Viking CCS Pipeline

9.53 Response to Natural England's Recommendations relating to the LWNL

Document Reference: EN070008/EXAM/9.53

Applicant: Chrysaor Production (U.K.) Limited,
a Harbour Energy Company
PINS Reference: EN070008
Planning Act 2008 (as amended)
The Infrastructure Planning (Applications: Prescribed Forms
and Procedure) Regulations 2009 - Regulation 5(2)(q)
Date: July 2024

Drawing title
LAYDOWN, WELFARE AND PARKING AREA
Regulation 5.2 (o)
Application Document Reference 4.13
(Sheet 1 of 1)

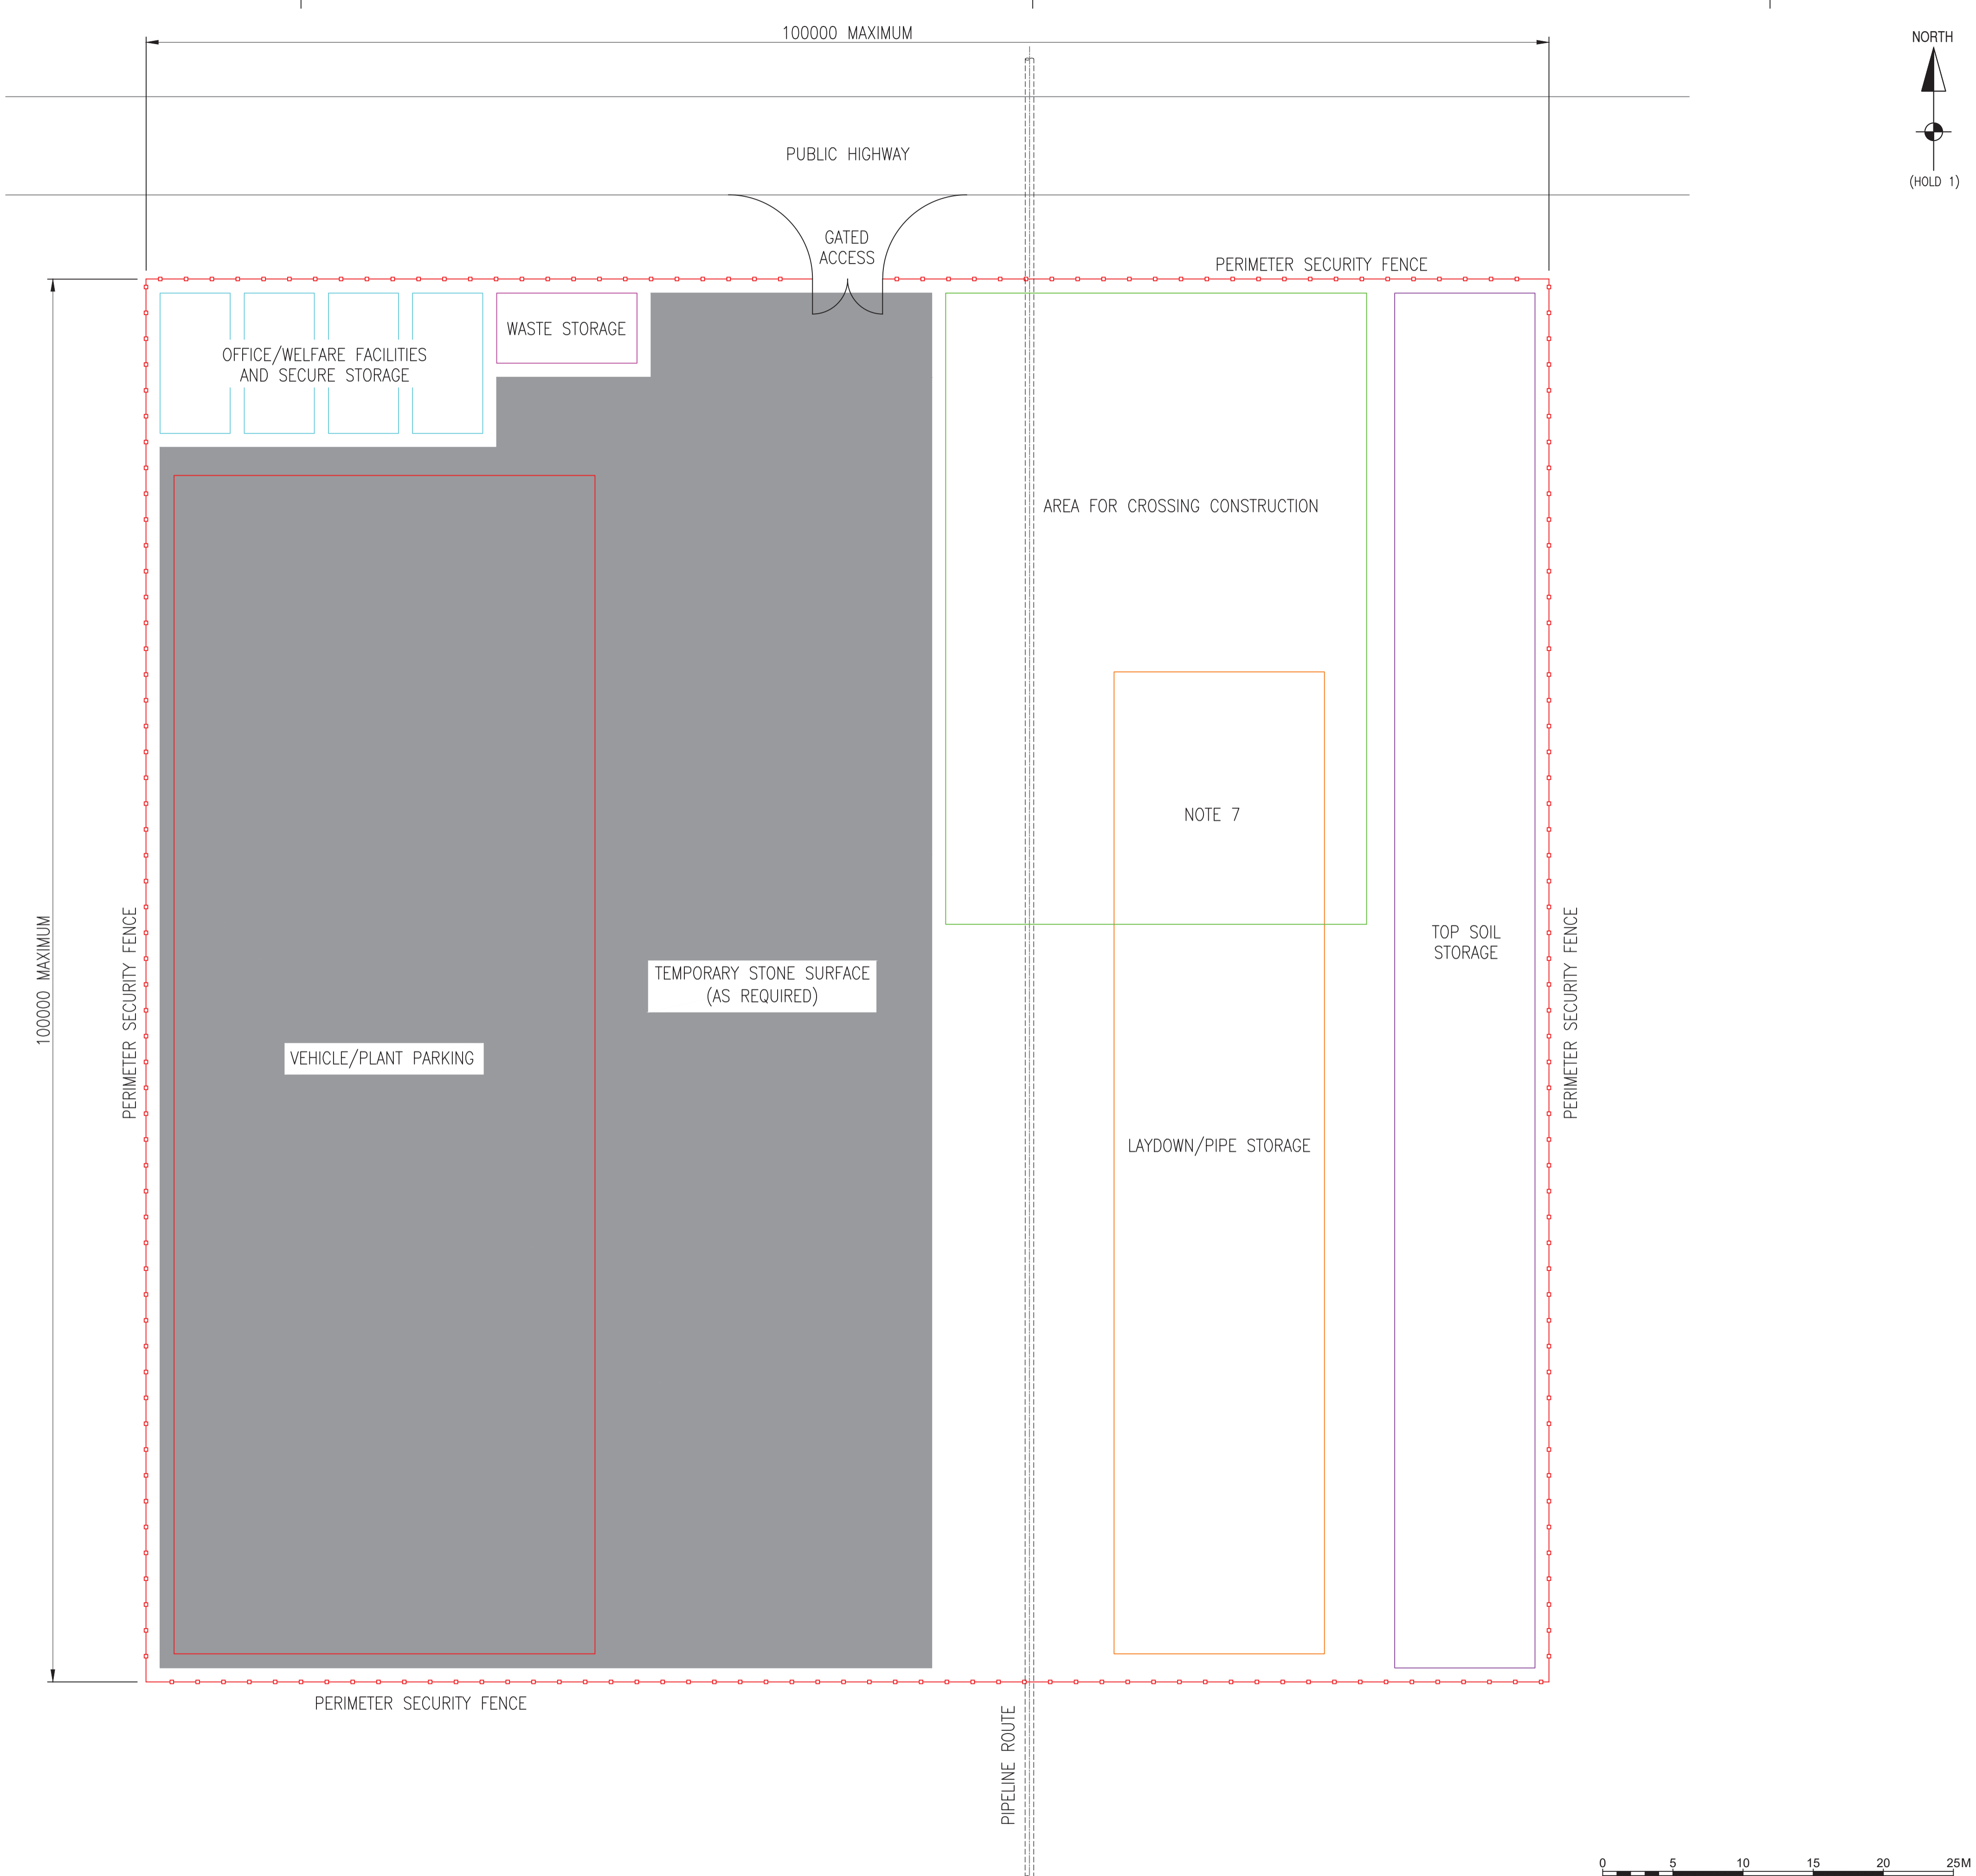
2.17.41	NE29f Protected Landscapes	<p>Comment Natural England advise that all visible surface infrastructure is considered within the landscape and visual assessment, inclusive of the temporary access and laydown areas, one of which includes HGV parking and hard infrastructure within the Lincolnshire Wolds National Landscape boundary near Irby upon Humber (Chapter 3, Figure 3-30 1 of 3, APP-045).</p> <p>Recommendation</p> <ul style="list-style-type: none"> Provide justification that all visible surface infrastructure is considered within the landscape and visual assessment. Ensure the landscape and visual assessment considers the impact of temporary access and laydown areas. 	<p>All visible infrastructure associated with the Proposed Development including the impact of temporary access and laydown areas have been assessed within ES Chapter 7 Landscape and Visual [APP-049].</p> <p>The assessment presented in ES Chapter 7 Landscape and Visual [APP-049] includes all visible infrastructure associated with the Proposed Development. Paragraph 7.8.2 to 7.8.6 notes the various elements potentially impacting landscape and visual receptors by category and stage (construction/operation). In the assessment each section has a summary of effects from the combined elements and if applicable those in other sections, noting that the pipeline is the main element which potentially gives rise to inter-section effects and there is little or no intervisibility from other elements such as BVS due to distance and intervening vegetation.</p> <ul style="list-style-type: none"> The assessment presented in ES Chapter 7 Landscape and Visual [APP-049] includes the impact of temporary access and laydown areas. Their presence is highlighted at Para 7.8.2 and then throughout the Visual Assessment as part of the construction activity described for individual viewpoints.
